**STATEMENT OF ENVIRONMENTAL EFFECTS: SECTION 75W APPLICATION TO MAJOR
PROJECT MP NO.10_0107 STAGE 1 (BUILDINGS 2) – 61 MOBBS LANE, EPPING**

Pursuant to Section 75W(1)(a) of the Environmental Planning and Assessment Act 1979, a 'modification of approval' is sought to vary Architectural Plan A1005-B, Rev A and Condition No. A2 pertaining to Major Project MP No. 10_0107 (as originally approved on the 17 January 2011, and as modified on the 21 October 2011). Minor modifications are sought to clarify construction details and correct a drawing error applying to Building 2. The changes do not alter the height, bulk or scale of the approved development.

2 BUILDING 2 - SOUTH ELEVATION
SCALE: 1:100

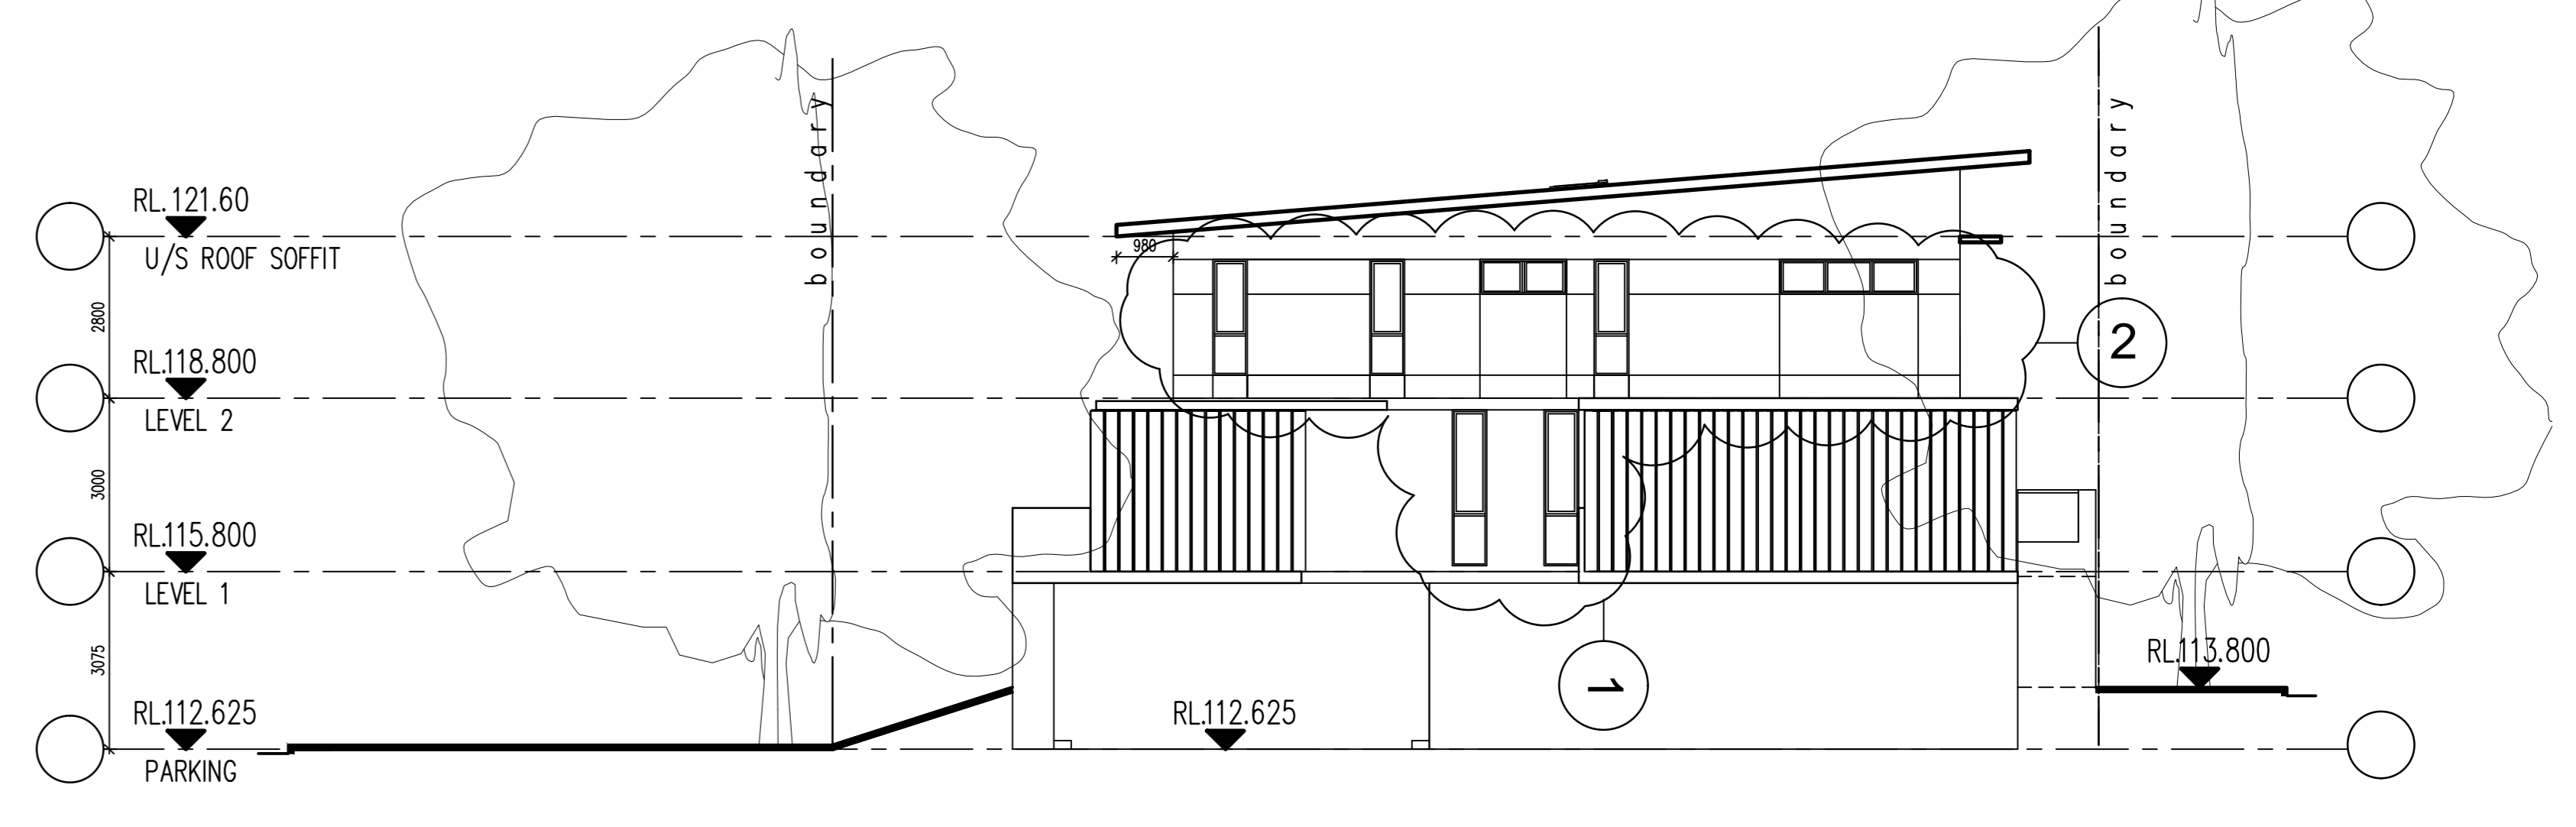
B2 Elevations (A1005) Rev B – South Elevation

1. Access points re-aligned.
2. Balcony identified.

4 BUILDING 2 - EAST ELEVATION
SCALE: 1:100

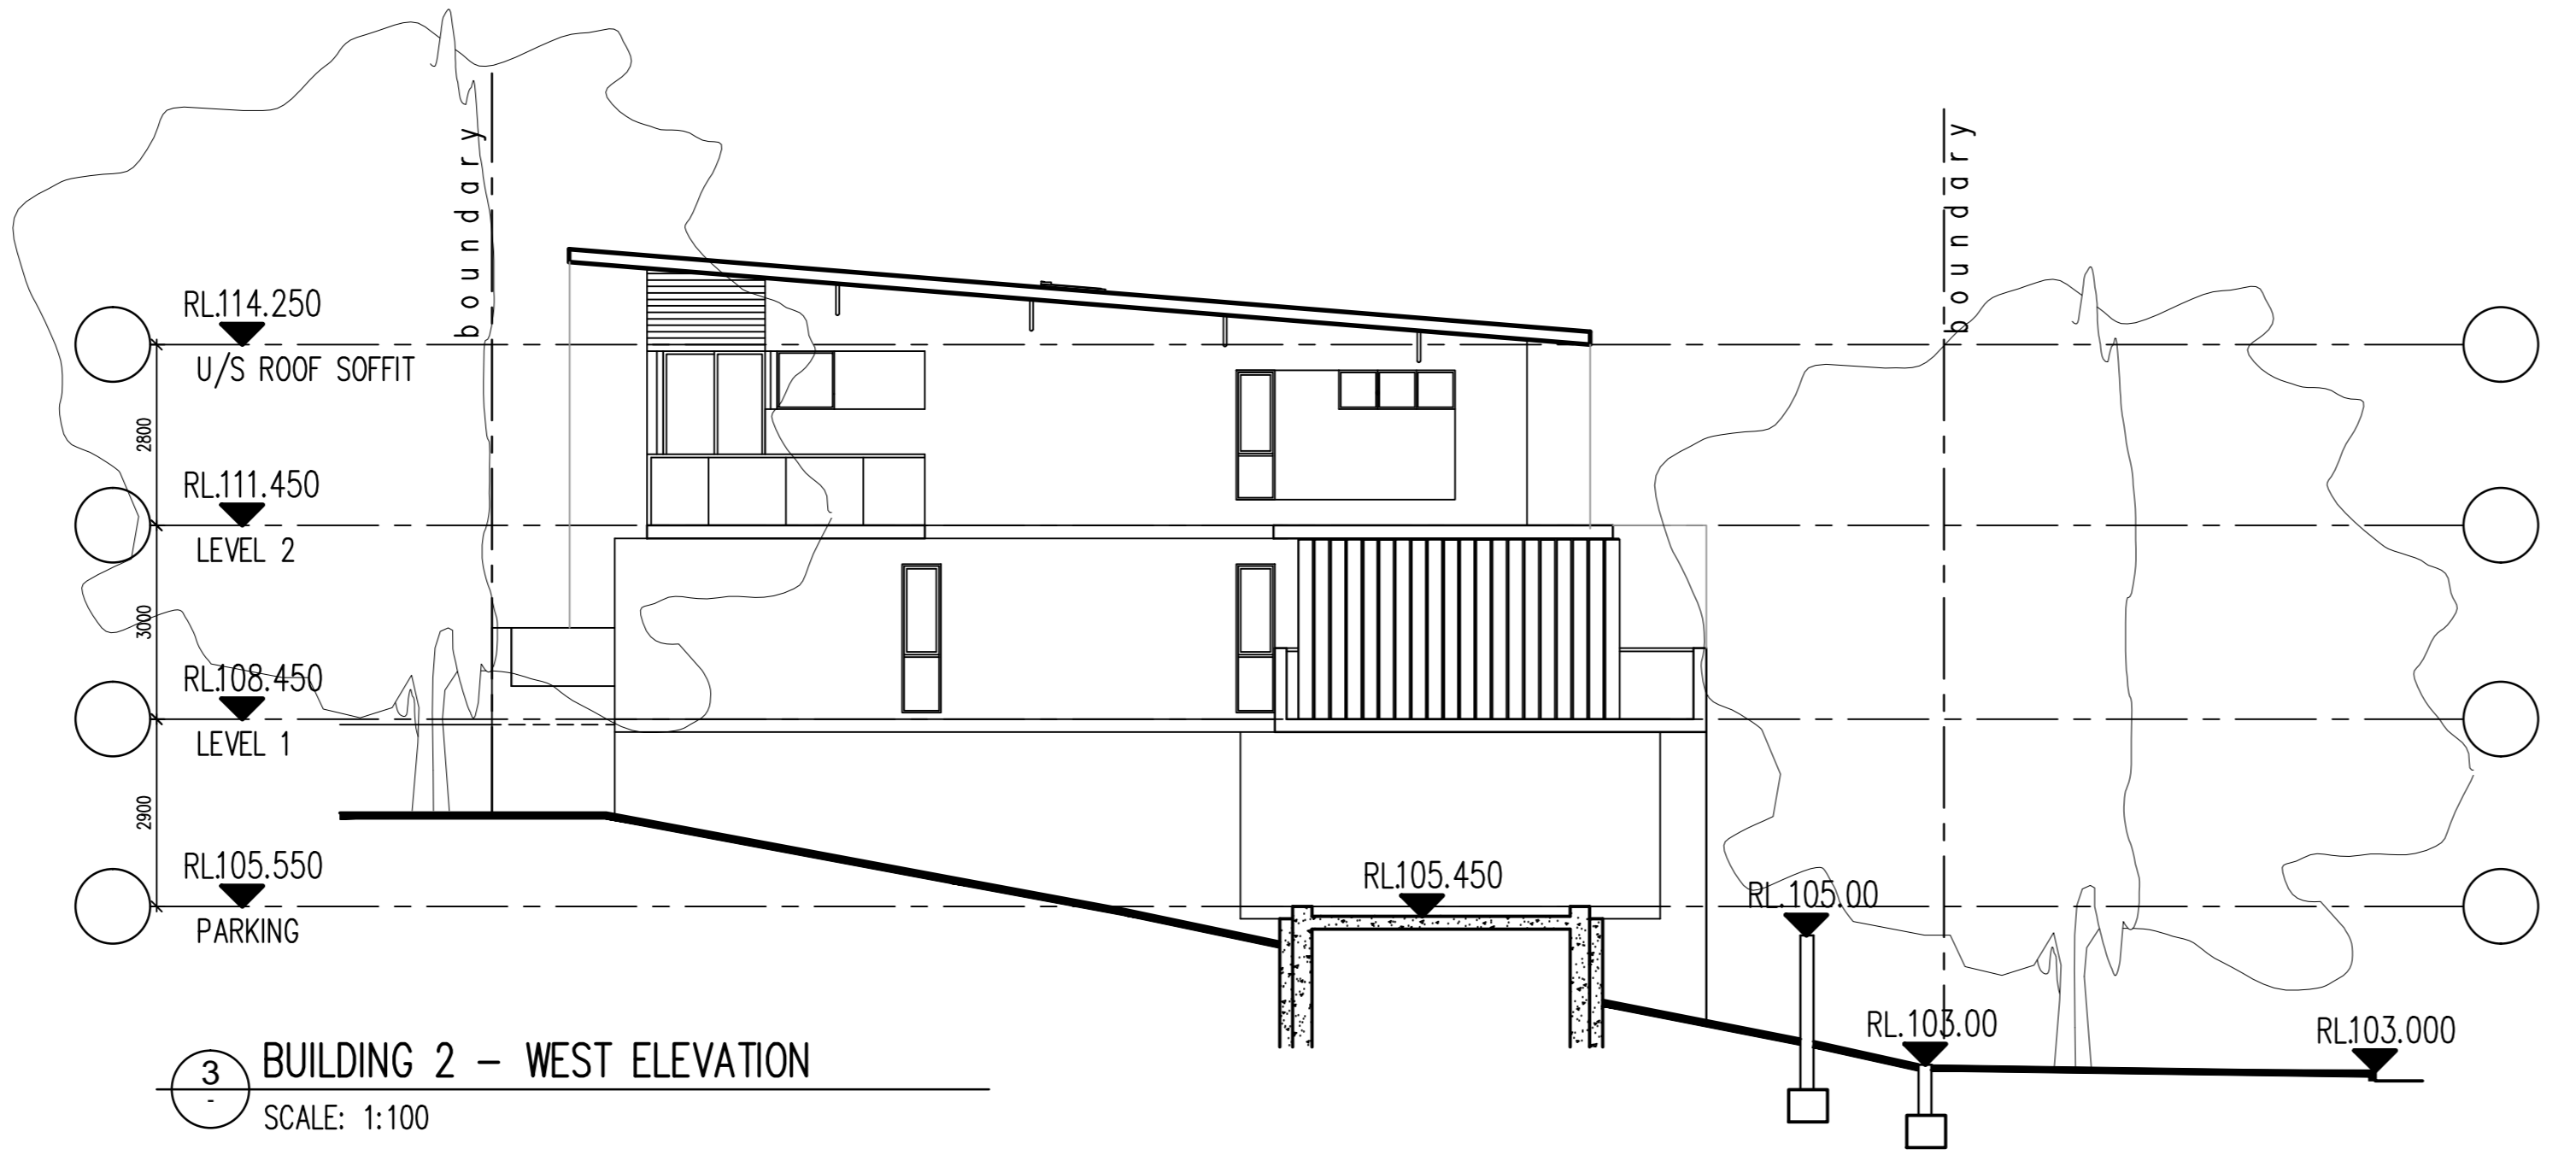
B2 Elevations (A1005) Rev B – East Elevation

1. Reconfiguration of windows.
2. Remove balcony, as shown.
